# CITY OF PORTLAND, MAINE

July 26<sup>th</sup>, 2011

**Project Name:** Harborview Townhomes  
New building comprising 7 residential units  
(19 space parking lot shared with existing 12 unit residential building)  
**Project ID:** 2011-214  
**Project Address:** 127 York Street (aka 121-129 York Street)  
CBL: 44 - A-004/005

## MEMORANDUM

PROJECT:
121 YORK ST.
PORTLAND, MAINE

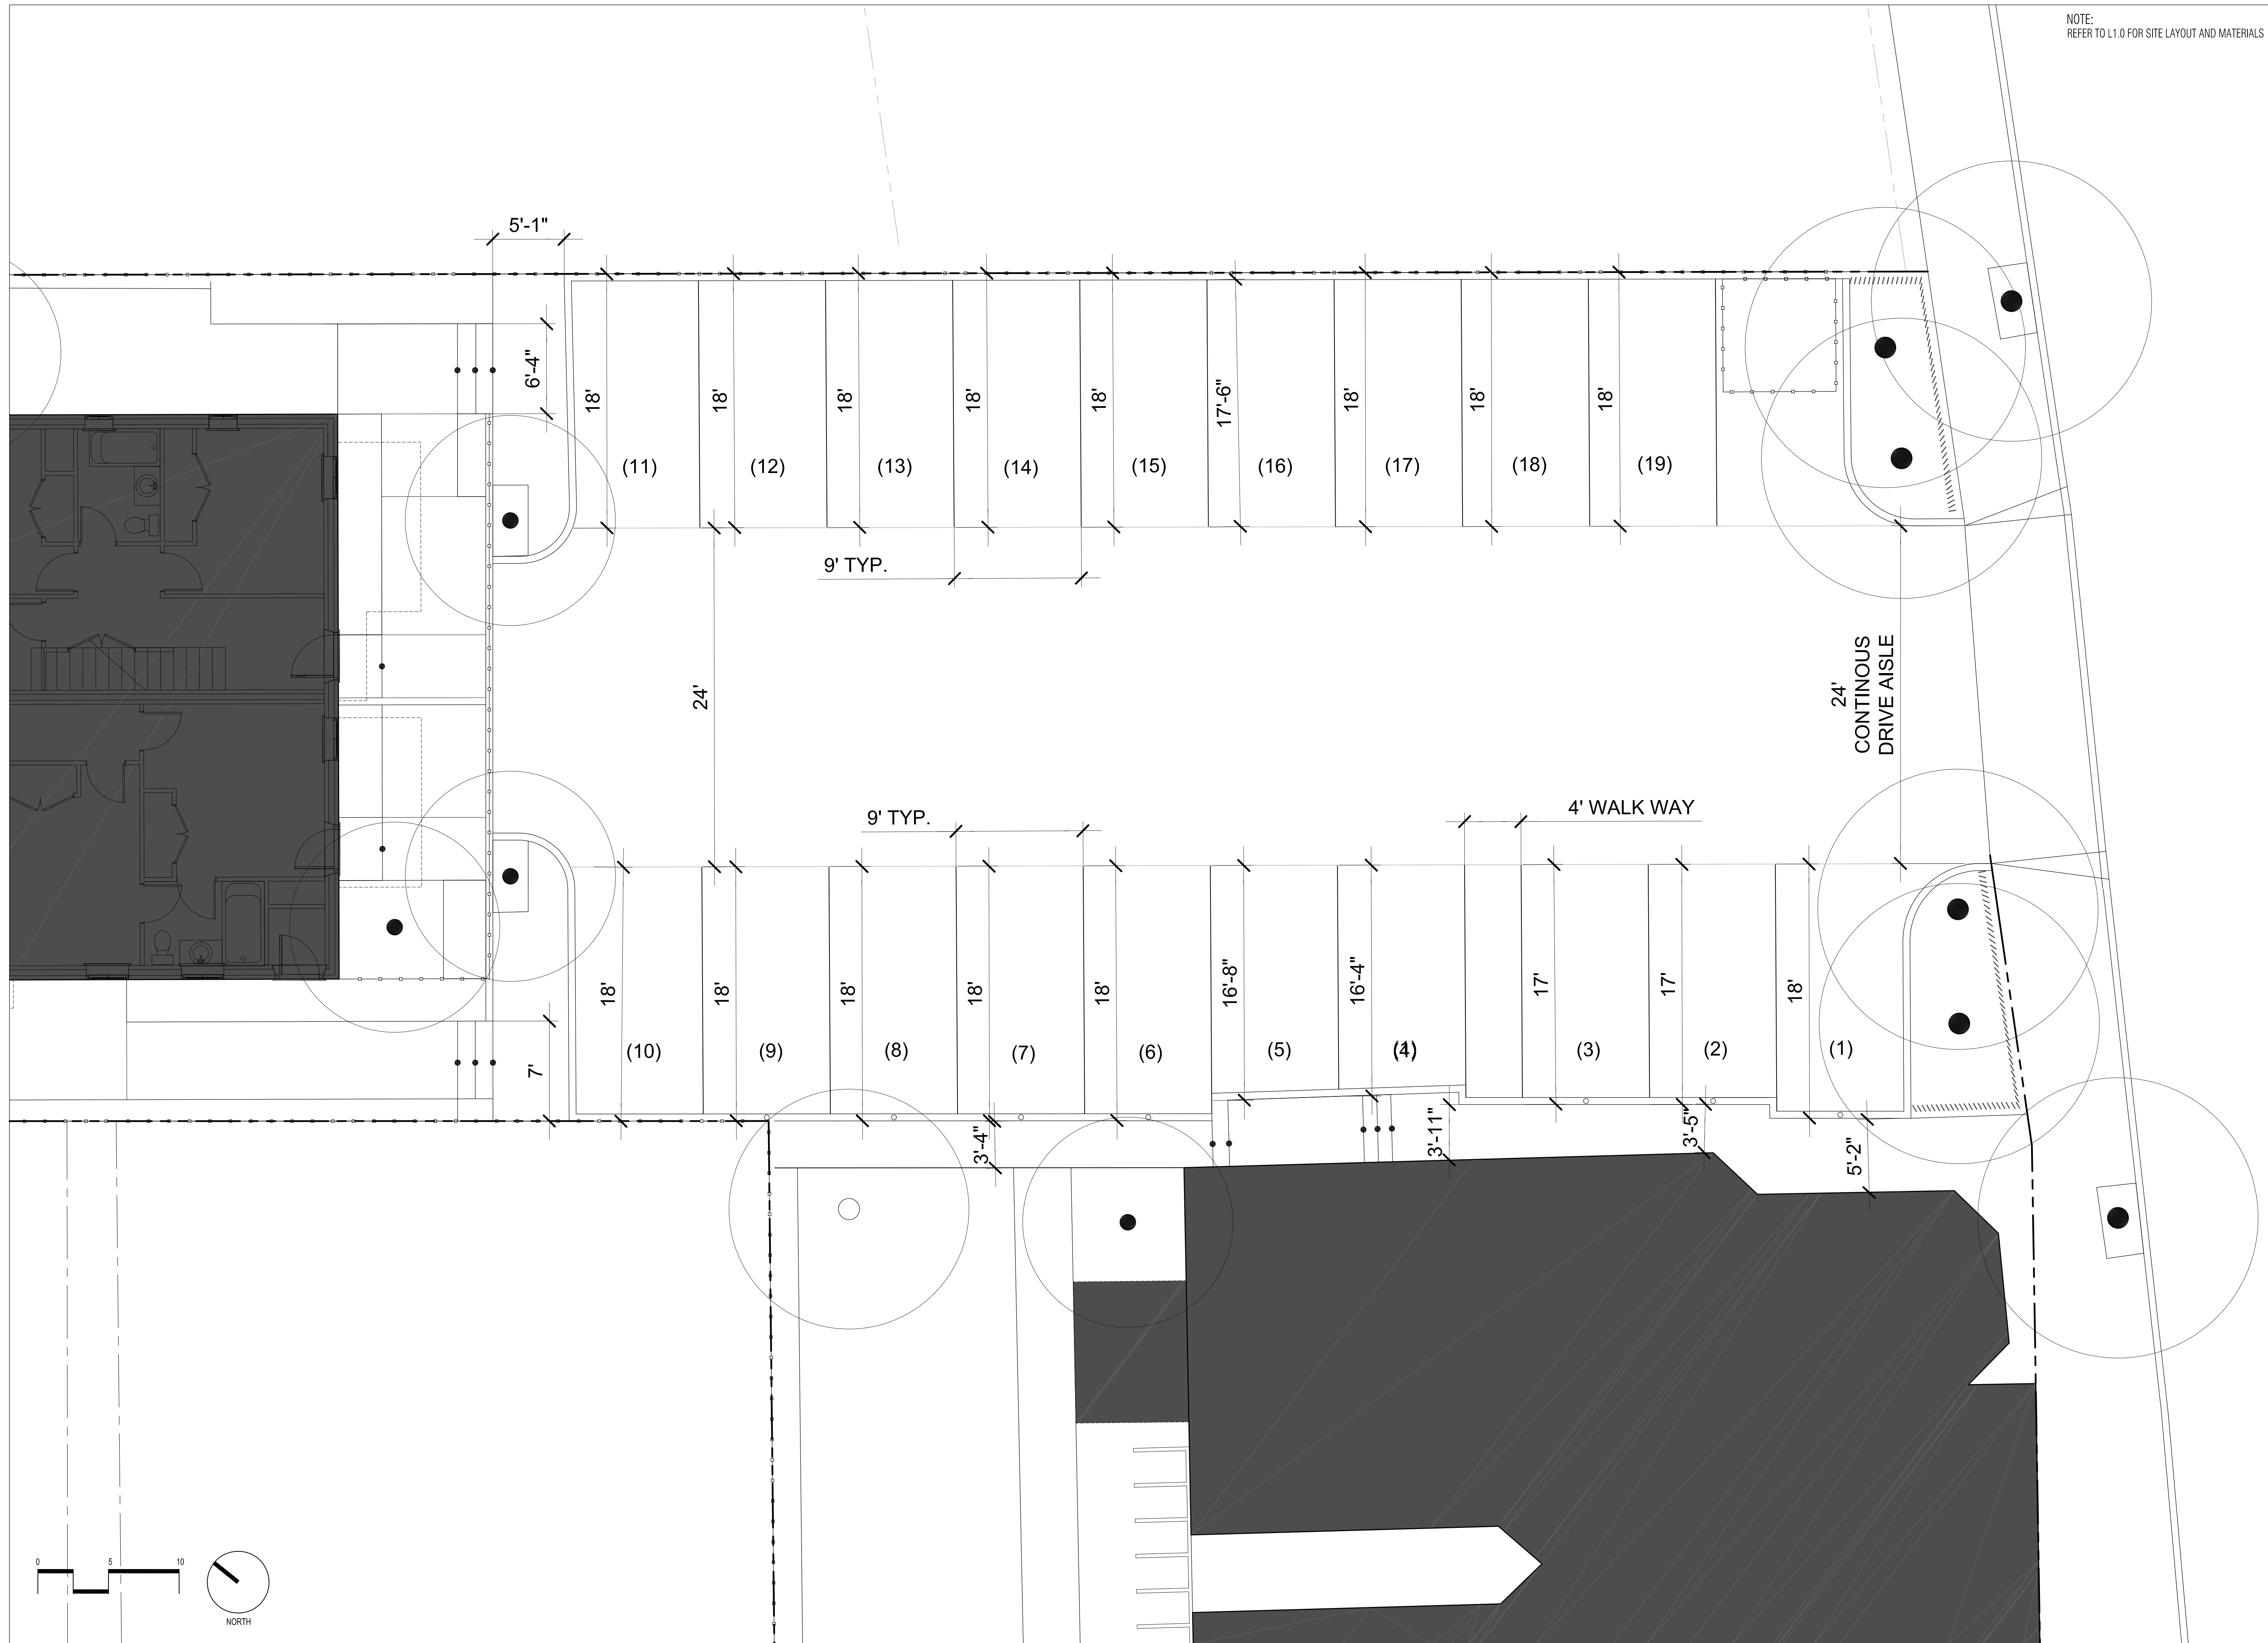
The Planning Board voted 6-0 (Morrissette absent) to waive Technical Standard, Section 1.14 to allow 4 of the 19 parking spaces to be compact parking spaces, as shown in the submitted plan "Exhibit A" (Attachment 4, page 4) dated 7.5.2011.

- ii. That the applicant shall submit revised site plans to incorporate the walkway route and associated revisions as shown in the submitted plan "Exhibit A" (Attachment 4, page 4) dated 7.5.2011, with the walkway section within the parking lot drive aisle to be a stamped pavement material of a different and visible color, for review and approval by the Planning Authority prior to the issuance of a building permit; and

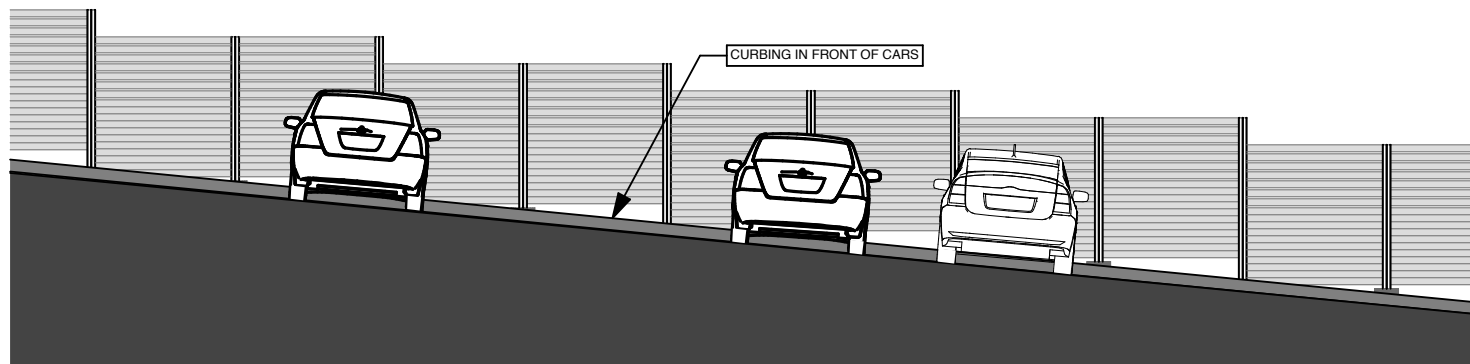
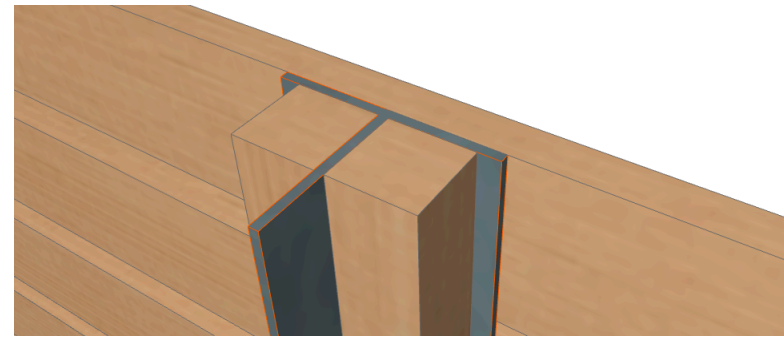
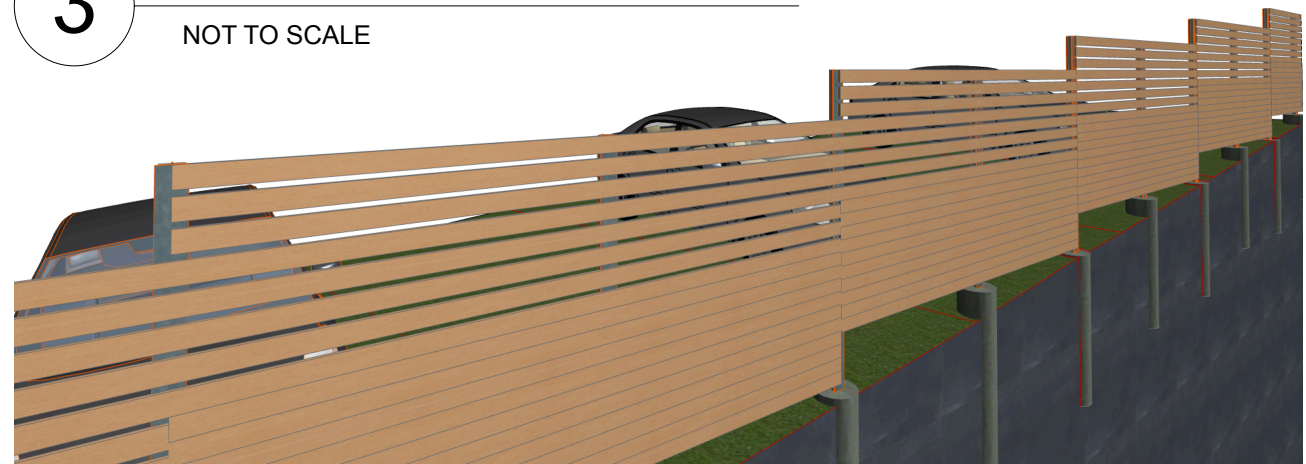
- i. That the applicant shall submit an example of the fence product proposed for the frontage of the property (or identify a location in the area where it can be seen) for review and approval by the Planning Authority prior to the issuance of a building permit; and
